19th June 2016

RE: Variation of Condition 2; Plan dated May 2016

With reference to the above variation on the approved plans of 45 Northaw Road East.

Rev	Details	Date
<b>MD DESIGNS</b>		
9 JEPPIES CLOSE, GOFFS OAK		
HERTS, EN7 6UT		
01992 630 520		
CLIENT	Mr & Mrs Ankesaria	
LOCATION	45 Northaw Road East Cuffley EN6 4LU	
PROPOSAL	variation of condition 2	
Date:	July 2016	
Scale:	A1@1:100	
Dwg:	nor/plan/16	
		01

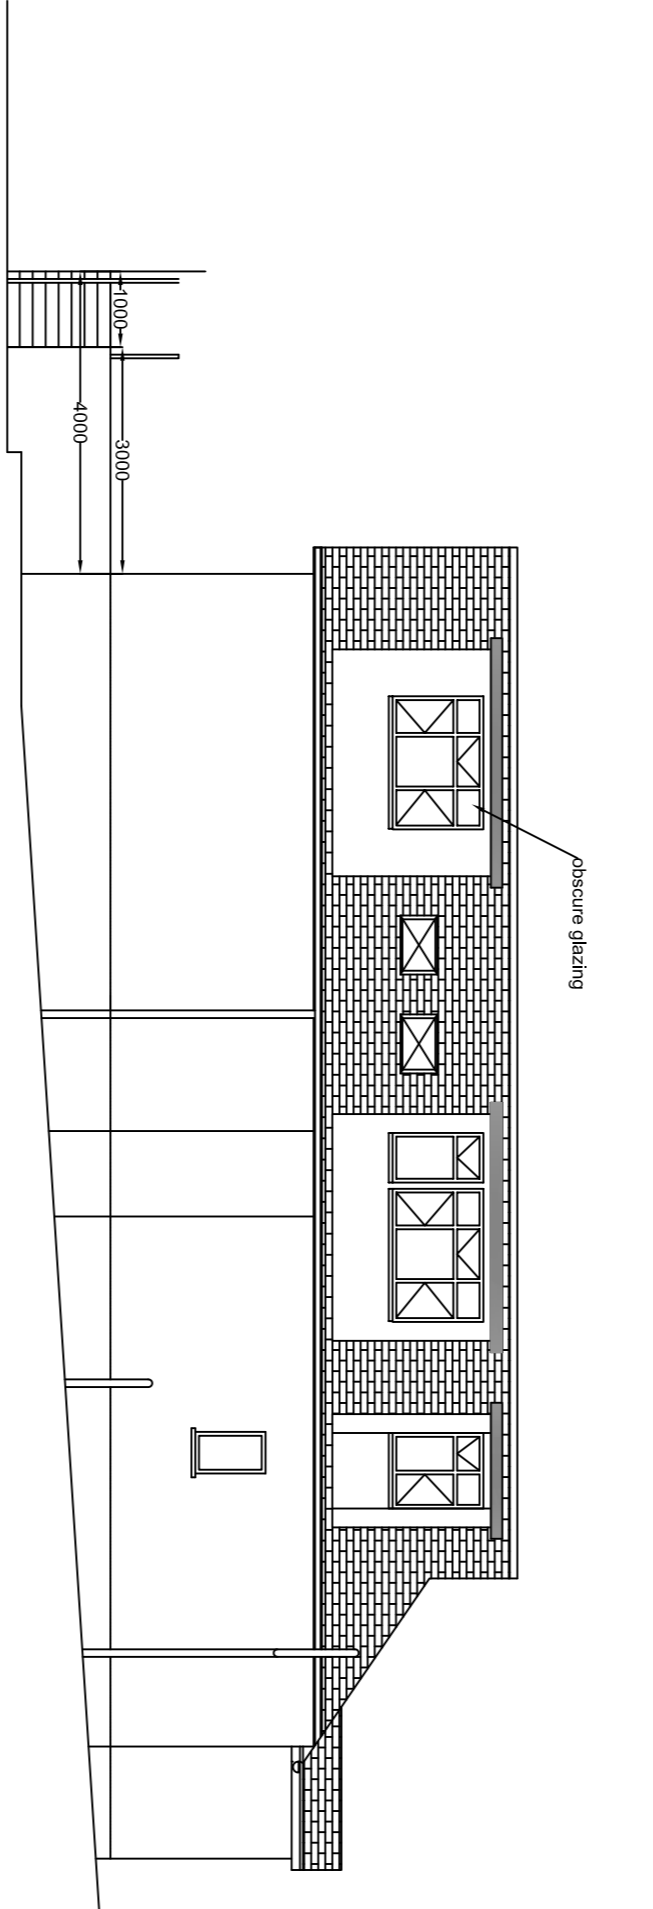
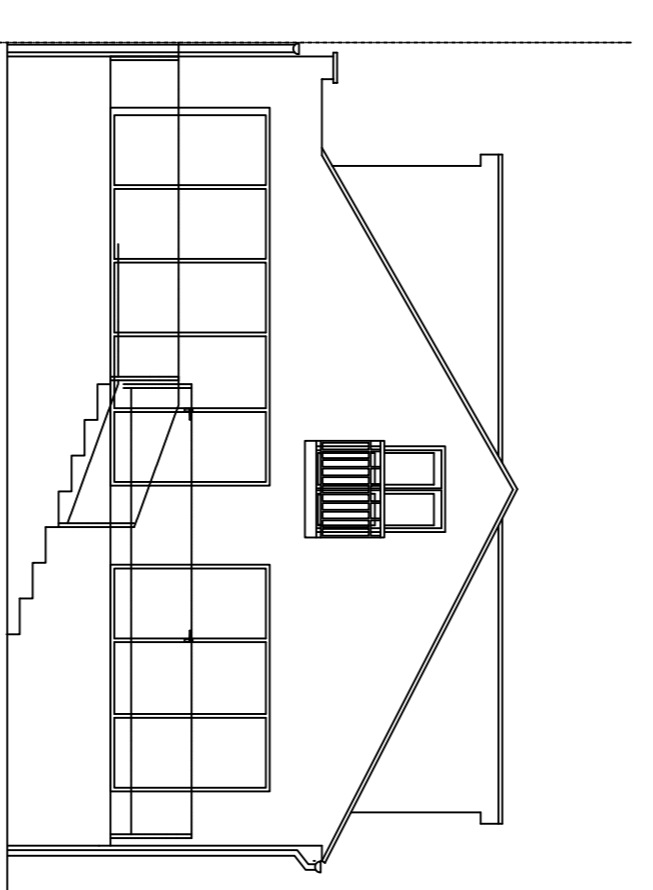
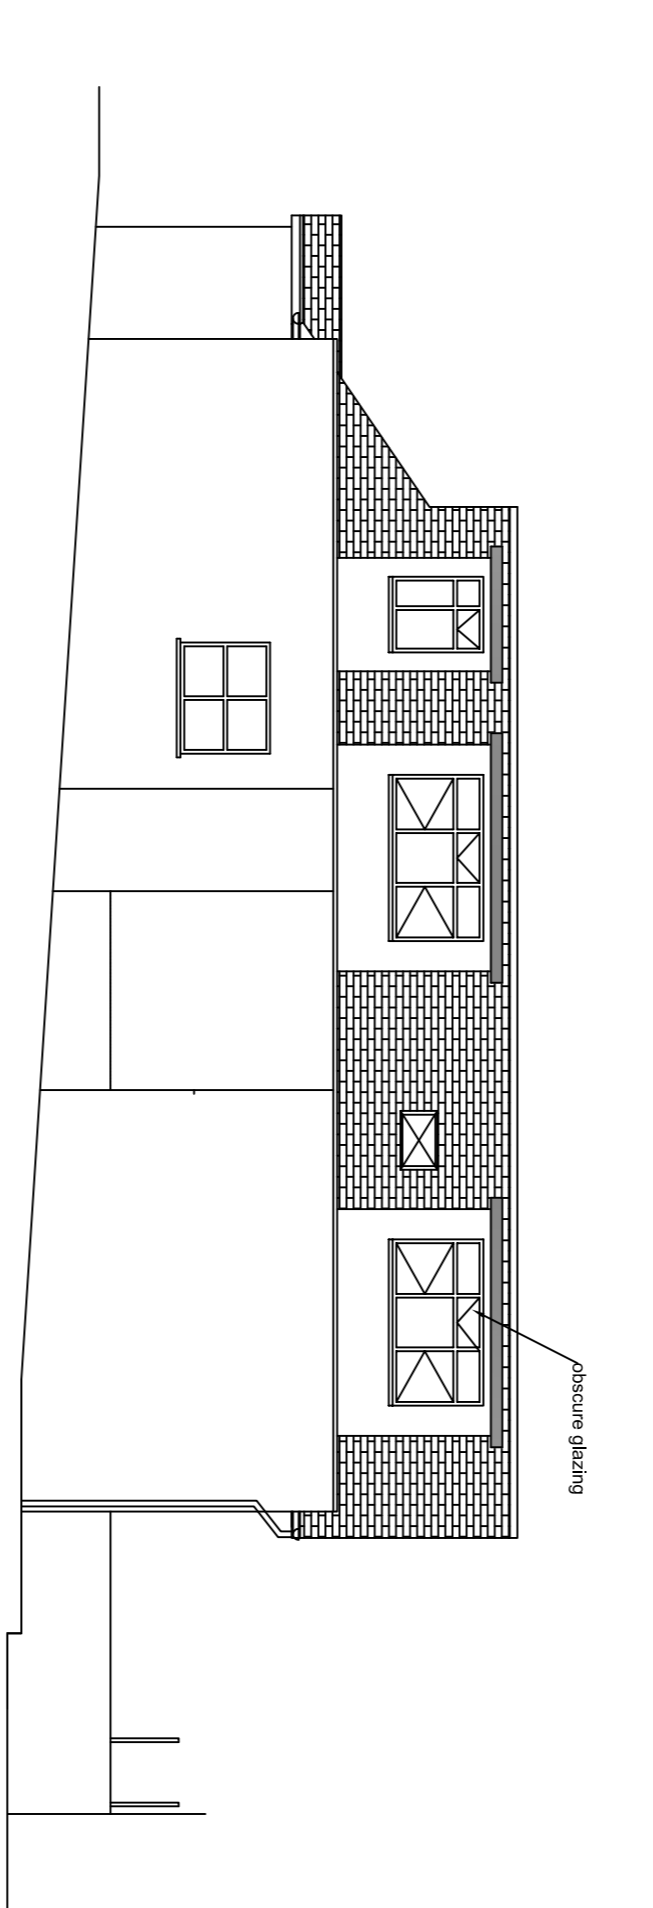
- The additional window (middle dormer facing our property) should not have been included in the first instance being that it was in contravention to the original approved plans.

- The windows of all the dormers both facing and overlooking our property are not fitted with obscure double-glazing. This additional window to the dormer, being at a higher level, further impacts upon our privacy with the windows directly overlooking our skylights in our bedroom and kitchen.

- The size of the dormers are not in keeping with the surrounding properties and are in excess of the approved plans. There is also a clear lack of separation between our property and that of No.45 which results in the extension being very overbearing towards our property, a matter made worse by the additional window.

In conclusion, we strongly object to this variation being approved and believe that this additional window must be removed.
